## **Development Facilitation Team (DFT) – Review Comments**

**Project No: PR-2023-008906      Date: 09/13/2023      Agenda Item: #6 Zone Atlas Page: H-16**

**Legal Description: Tracts 1 & 2 Jones Industrial Park**

### **Application For: SD-2023-00168-Preliminary/Final Plat (DHO)**

SKETCH PLAT FOR
 LOT 1-A
 JONES INDUSTRIAL PARK
 SITUATE WITHIN
 SECTION 10, T. 10 N., R. 3 E., N.M.P.M.
 CITY OF ALBUQUERQUE
 BERNALILLO COUNTY, NEW MEXICO
 JUNE 2023

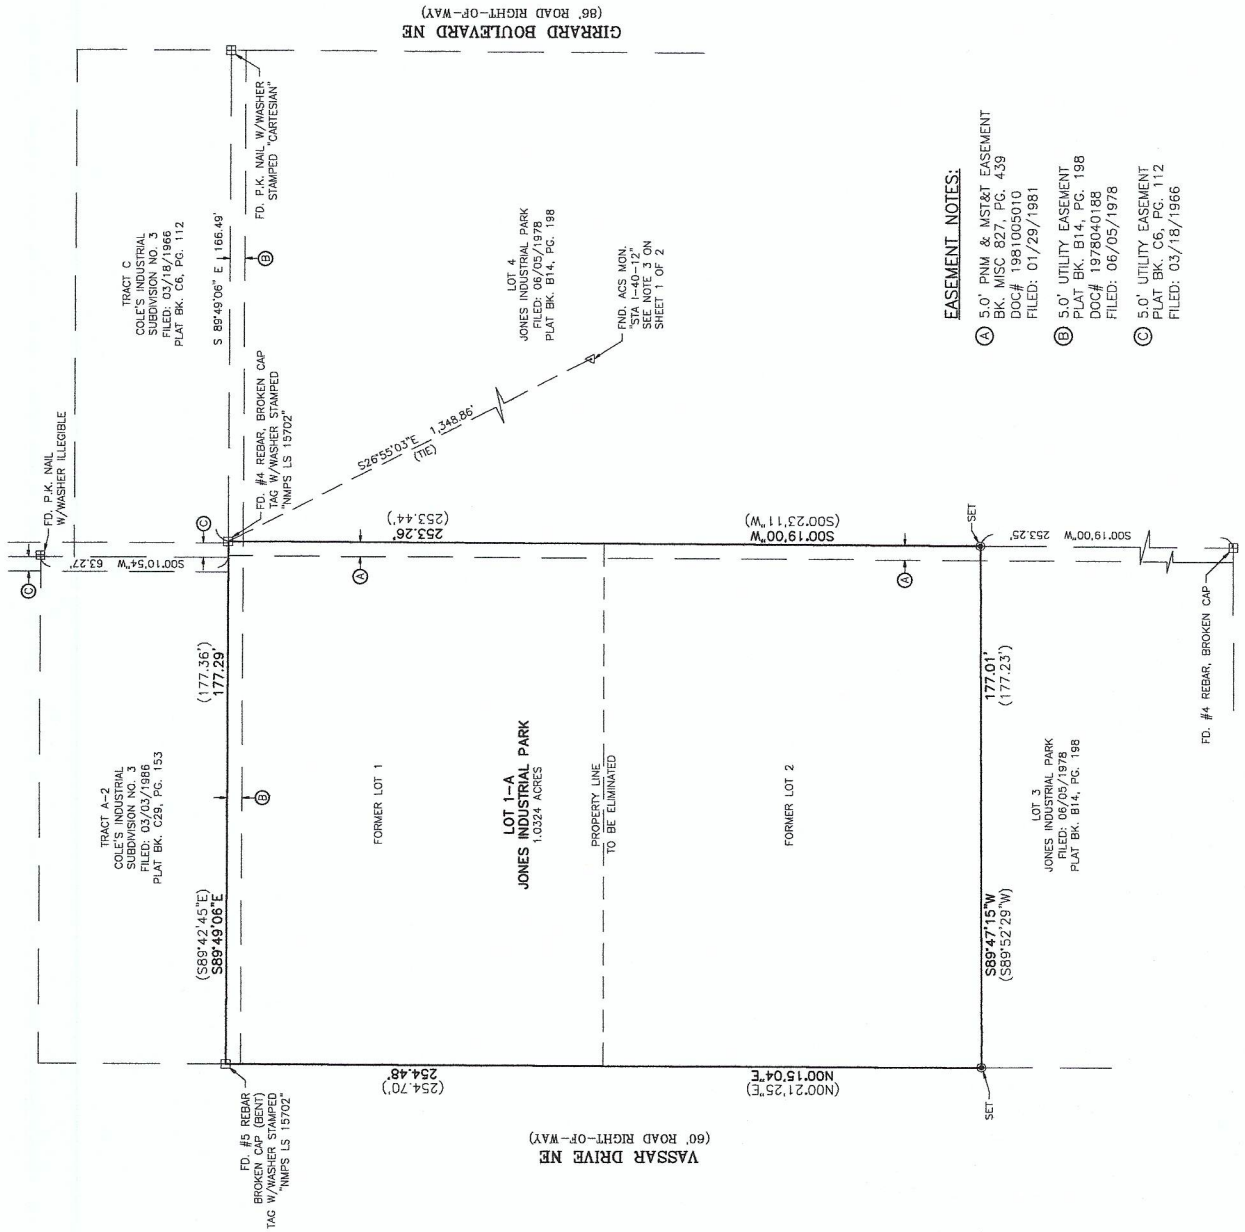
1. Vasser is a local street and requires 5' sidewalk with a 4-6' landscape buffer. In order to allow the existing sidewalk to remain we will need for 5' square passing areas be created along the sidewalk at no greater than every 200' to meet ADA standards.
2. Any future development would require an approved TCL prior to site plan or building permit.

- The applicant is seeking a determination to allow the existing 4' sidewalks along Vassar Dr to remain in lieu of the 5' sidewalk. Planning defers to Transportation.
- Property is within the Menaul & University Landfill Buffer. Development will require Environmental Health approval. Please add the following note regarding this item to the title/cover page of the plat:

- Demonstrate compliance with **section 7 of the DPM Table 7.2.29** and Required Improvements section from 5-4(N) of the IDO. In regards to the Sidewalk width requirements and the accompanying landscape buffer.

**\*Verification of standards per Transportation\***  
Provide measurement for the existing ROW and distance from curb to property line along street frontages.

- Vassar is a local street. Not in a Center or Corridor area.  
Requires a 5ft side walk and 4-6ft landscape buffer. **Please clarify buffer zone along the sidewalk and street trees.**

- The subject site currently has two curb cuts and the applicant intends on removing them and replacing them at different locations. Sidewalks, modified curb and gutter will replace the curb and cuts. An infrastructure list has been provided to demonstrate these modifications; **A recorded Infrastructure Improvements Agreement (IIA) must be recorded and submitted to staff before final sign-off of the Plat.**
